# Rezoning Transportation Analysis

Petition Number: 2024-042

General Location Identifier: 04321314

Date	Description
4-24-24	First Review (TM)

# SUBDIVISION SITE PLAN

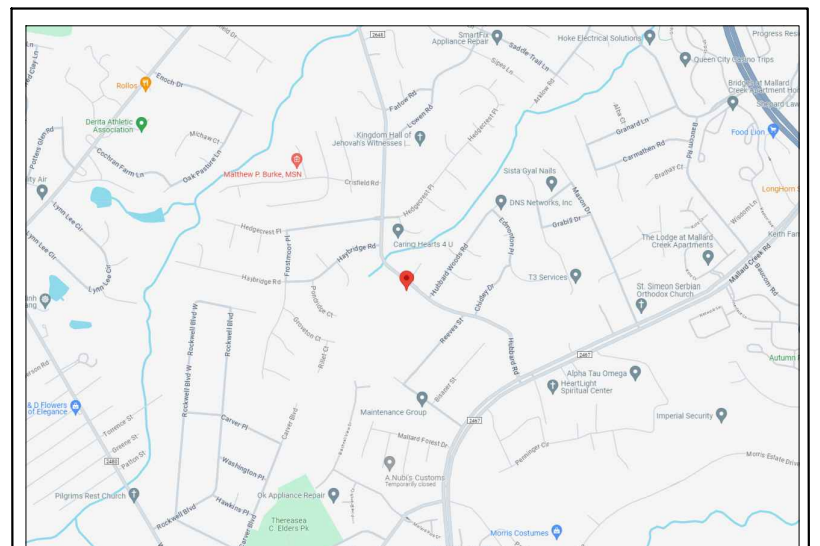
- a. **Hubbard Road:** Location of future back of curb and gutter to follow CLDSM U-07B with a back of curb location at 17.5-feet from roadway centerline.

Label and dimension the curb and gutter from the centerline for each road on the site plan.

3. Revise site plan and conditional note(s) to commit to dedicate a minimum of 33.5-feet of right-of-way from the road centerline of Hubbard Road. The site plan shall label and dimension the right-of-way from the road centerline.
4. Revise site plan and conditional note(s) to commit to dedicate a minimum of 33.5-feet of right-of-way from the road centerline of all internal proposed public roadways. The site plan shall label and dimension the right-of-way from the road centerline.
5. Revise site plan and conditional note(s) to commit to constructing internal public roadways to CLDSM U-03 roadway cross section per UDO chapter 33 table 33-2 requirements. ([Microsoft Word - CLDSM Cover.doc \(charlottenc.gov\)](#))

6. Revise site plan and conditional note(s) to commit to constructing an 8-foot planting strip and 8-foot sidewalk on all public roadway frontages per UDO chapter 33 table 33-4 requirements.

- Revise site plan and conditional note(s) to commit to constructing all roadways per CDOT standards. All vertical and horizontal alignments must be adhered too. Site plan shall show, label and dimension each roadway on site plan. Label each roadway with the CLDSM standard used.

- Revise site plan and conditional notes to remove the southernmost site access to Hubbard Road due to Access restriction requirements per Charlotte Streets Manual and not meeting intersection spacing requirements.

9. Revise site plan to show sight triangles at the corner of each public roadway intersections.

10. Revise site plan and conditional notes to commit to stubbing the western most cul de sac to the property line.
